# Rezoning Transportation Analysis

Petition Number: 2023-022

General Location Identifier: 02954104

Date	Description
06-28-23	First Review (TM)

SCHEMATIC SITE PLAN

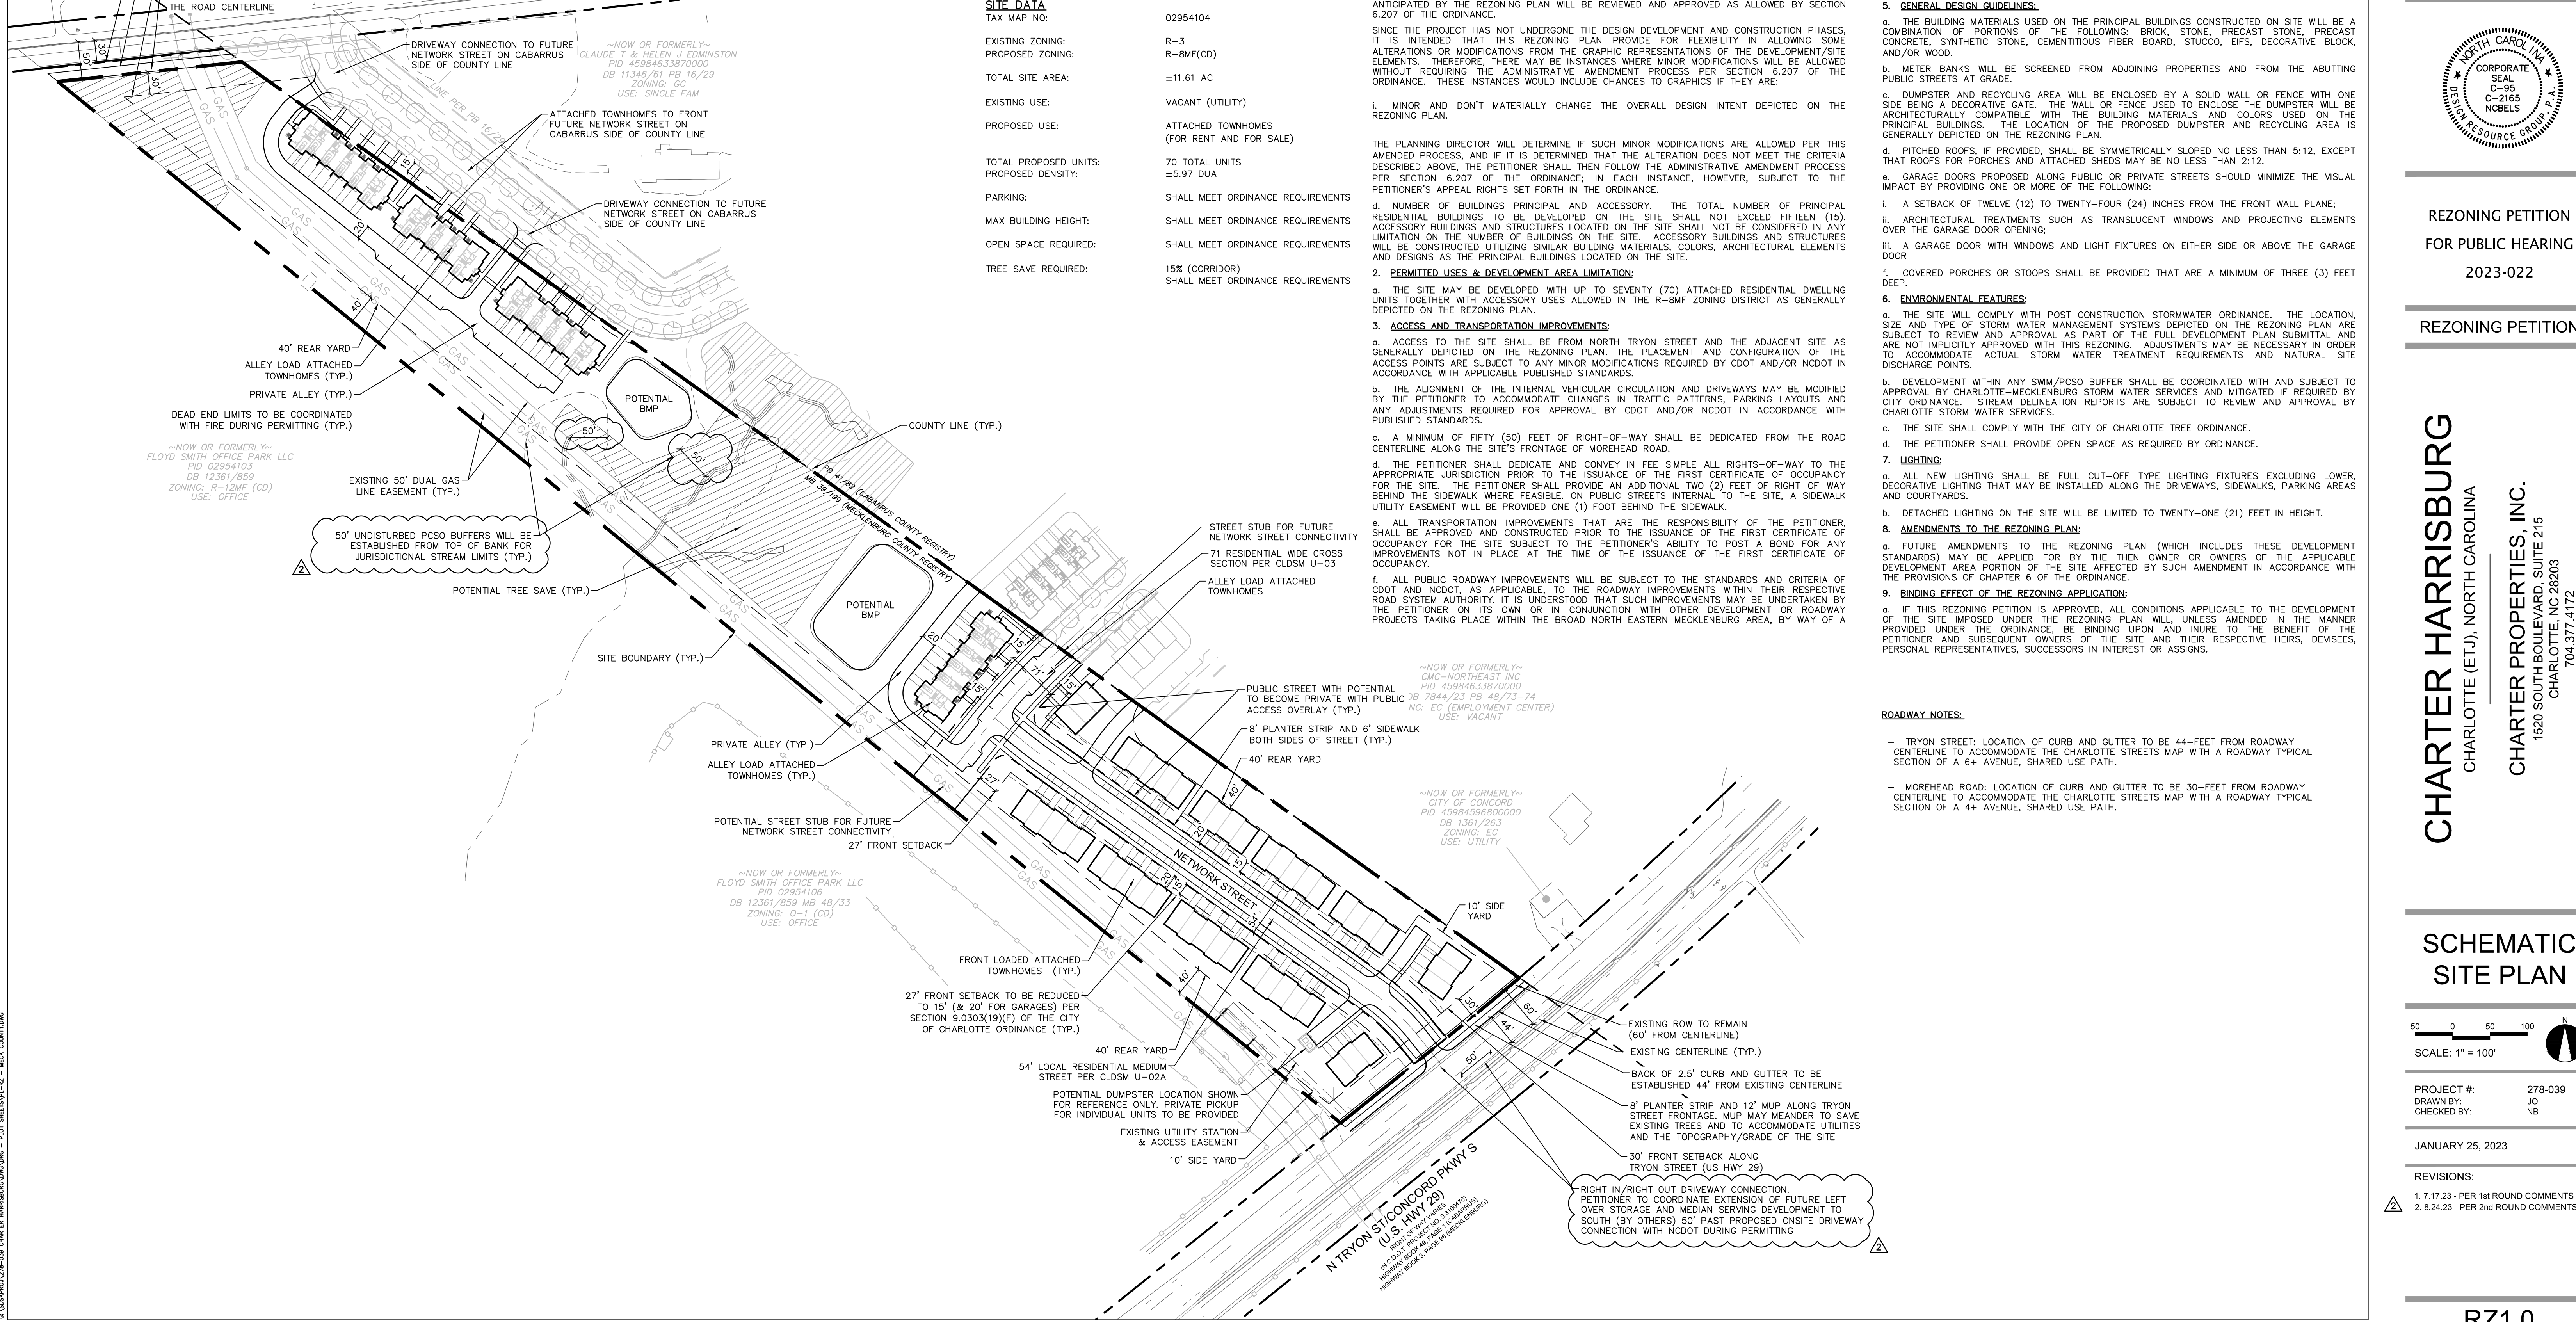
- a. **Tryon Street:** Location of curb and gutter to be 44-feet from roadway centerline to accommodate the Charlotte Streets Map with a roadway typical section of a 6+ Avenue, Shared Use Path.
- b. **Morehead Road:** Location of curb and gutter to be 30-feet from roadway centerline to accommodate the Charlotte Streets Map with a roadway typical section of a 4+ Avenue, Shared Use Path.

Label and dimension the curb and gutter from the centerline for each road on the site plan.

- 3. Revise site plan and conditional note(s) to commit to dedicate a minimum of 50 right-of-way from the road centerline along the sites frontage of Morehead Road. The site plan shall label and dimension the right-of-way from the road centerline.

- 4. Revise site plan and conditional note(s) to commit to construct bicycle facilities by installing a 12' multi-use path along both Tryon Street and Morehead Road to meet the Council-adopted Charlotte BIKES Policy. Multi-use paths maintained by the City shall meet ADA/PROWAG requirements.

6. Revise site plan and conditional note(s) to commit to removing the Tryon Street Access point in coordination with NCDOT. Site shall utilize the internal street network within the adjacent development.

7. Revise site plan and conditional notes(s) to identify who is maintaining the internal public street network.
8. Add a conditional note specifying “the Petitioner shall dedicate and convey in fee simple all rights-of-way to the City before the site’s first building certificate of occupancy is issued. CDOT requests rights-of-way set at 2’ behind back of sidewalk where feasible.”

11. Revise site plan and conditional note(s) to construct a 8-foot planting strips and 12-foot multi-use paths on Tryon Street and Morehead Road. The site plan shall label and dimension both items from the back of curb and gutter or edge of pavement. Add conditional note the entire facility must be outside of the right of way and within a public access easement. Add conditional note committing to construction and maintenance of the 12-foot multi-use paths on Tryon Street and Morehead Road.
